Dear Sir Planning Application No: 3/2022/0505

I wish to object to this planning application on the following grounds:-

Drawing Title
 PROPOSED ELEVATIONS

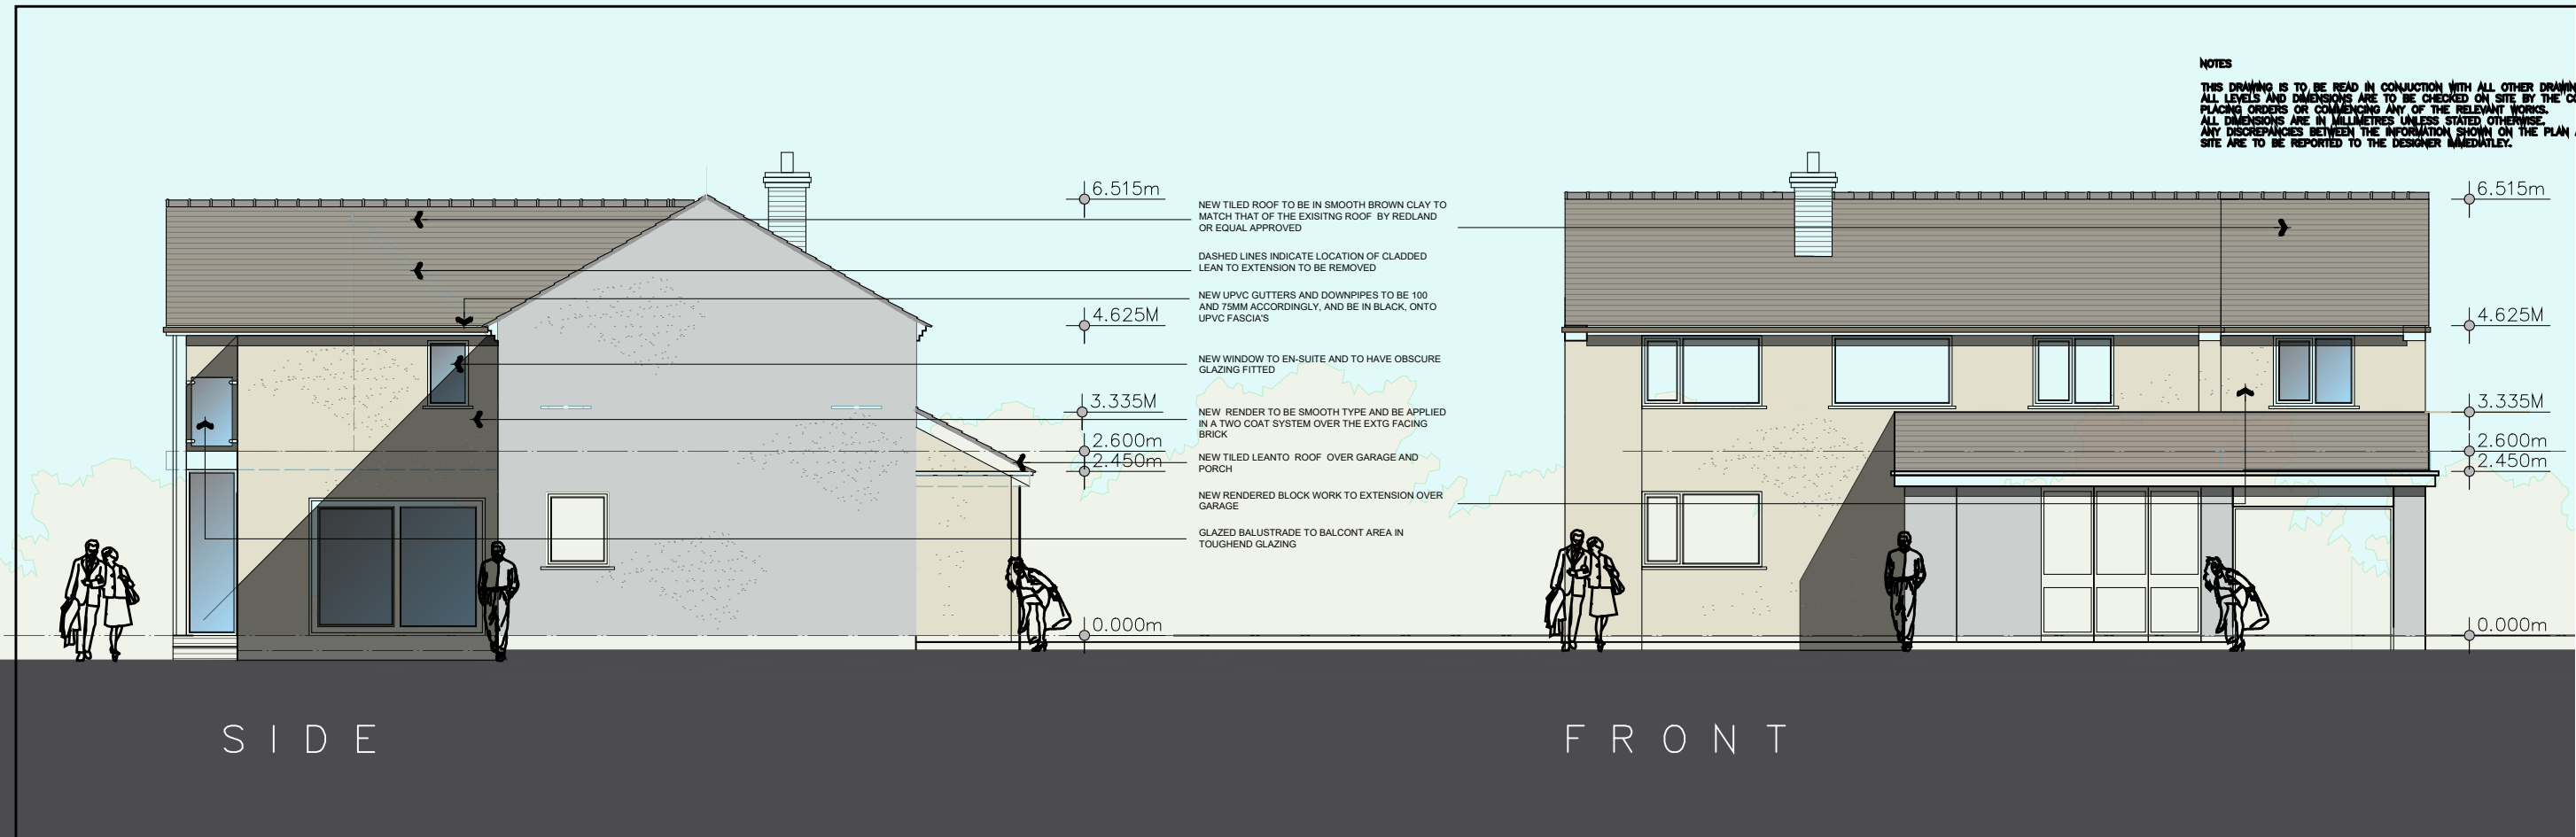
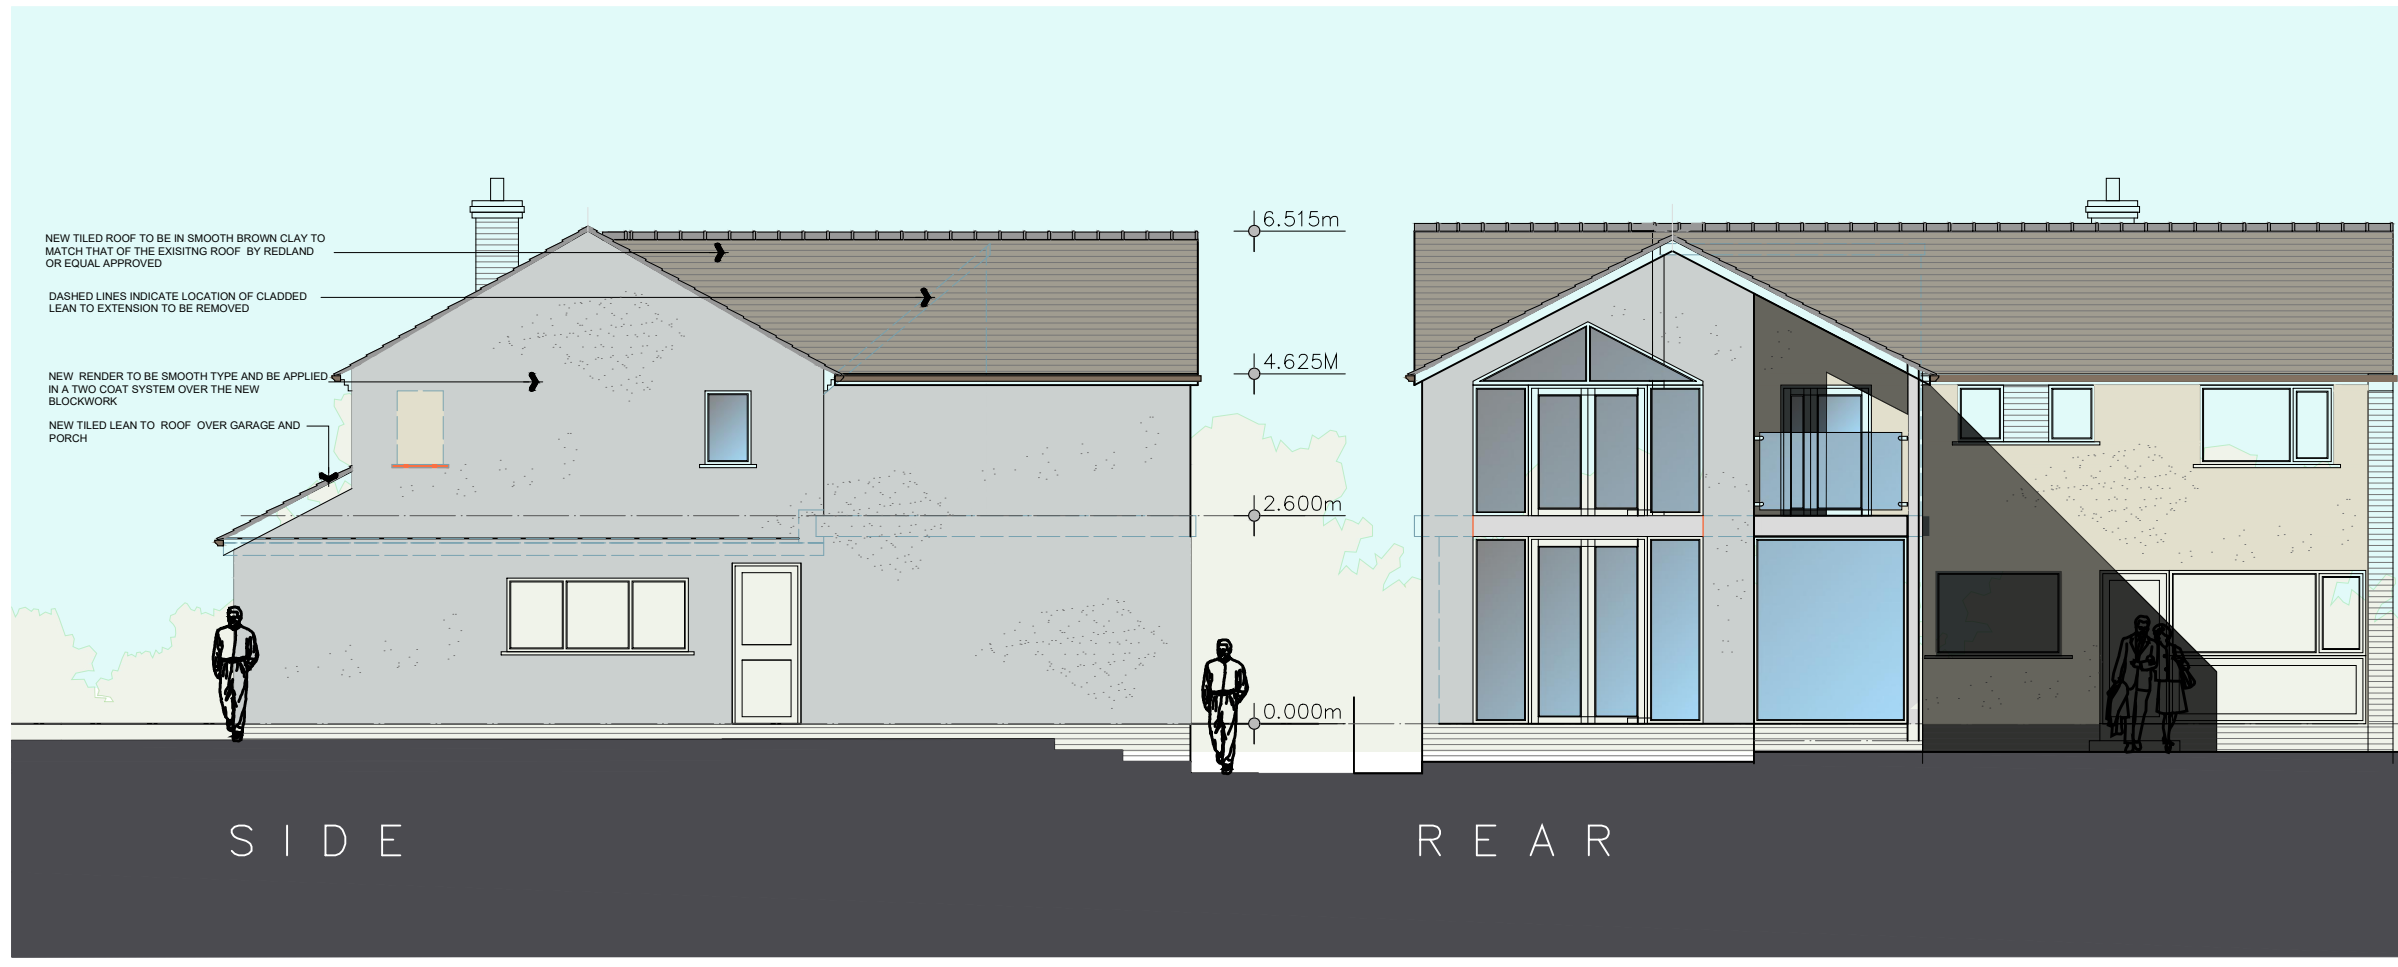
- ① The height & length of the extension over the garage which 
- ② The proposed new window on that extension

PROPOSED PLANS

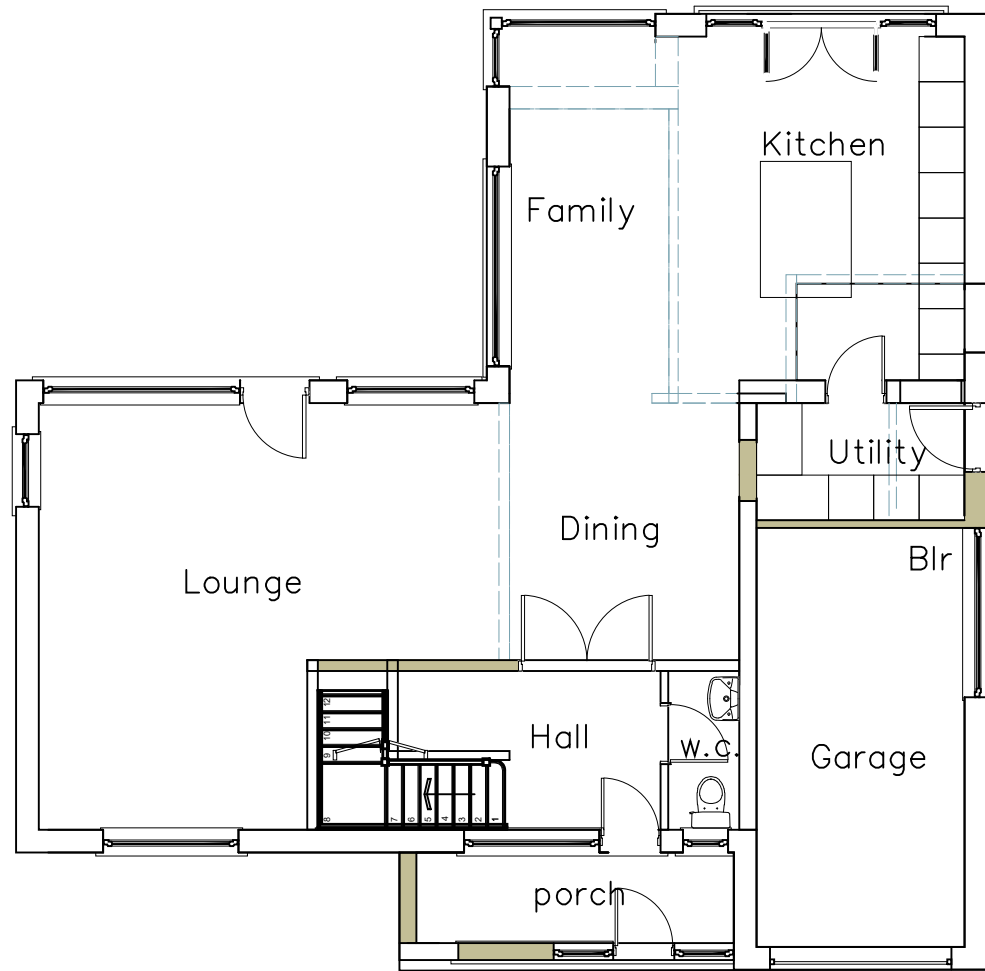
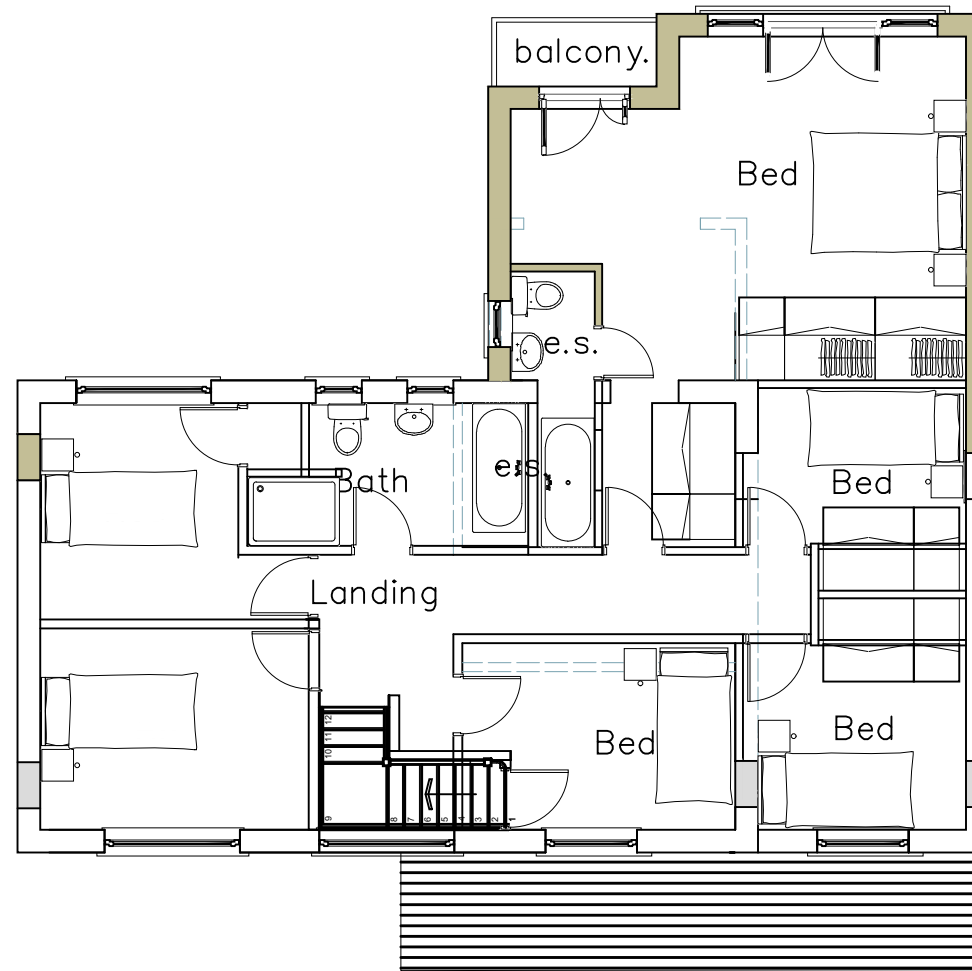
- ③ We assume there will be no first floor extension above the existing kitchen as this is not mentioned in the ^{proposed} planning application which we have received dated 24th June
